August 12, 2014

Re: Status of Improvement Permits - Trotter's Ridge
Applications #14-5-34119 - Lt 32 & #14-5-34140 - Lt 32-A

Bryan McSwain, R.E.H.S.
Environmental Health OSWW Program Specialist
Harnett County Department of Public Health

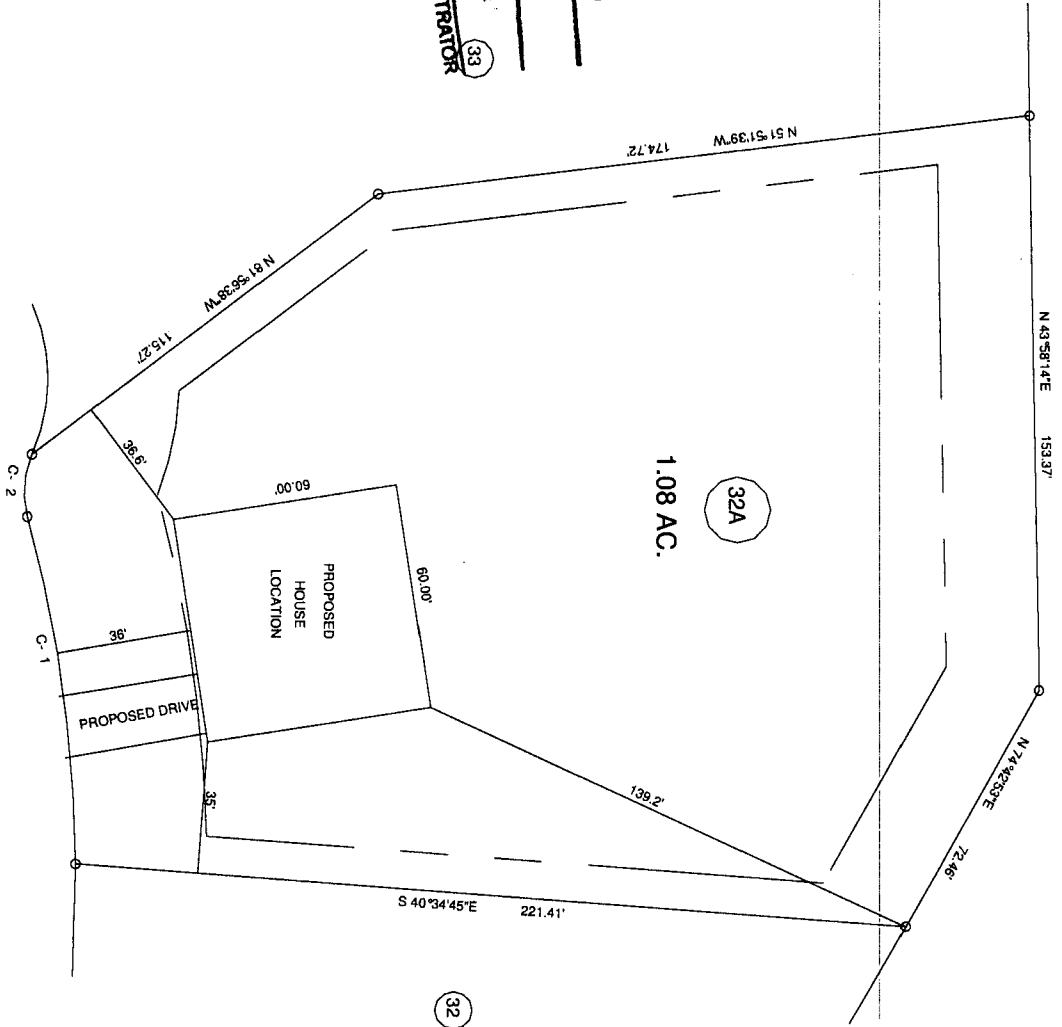
- 1. Use pink flags to mark property lines and irons that are set by surveyor need to be visible (*\$25.00 fee incurred*)
- 2. Use orange flags to mark house corners (*\$25.00 fee incurred*)
- 3. Directions not clear to property (*\$25.00 fee incurred*)
- 4. Lt. 32-A needs only brush or vegetation removed
- 5. Driveway not shown on site plan
- 6. Lt. 32 Requires backhoe pits
- 7. Other
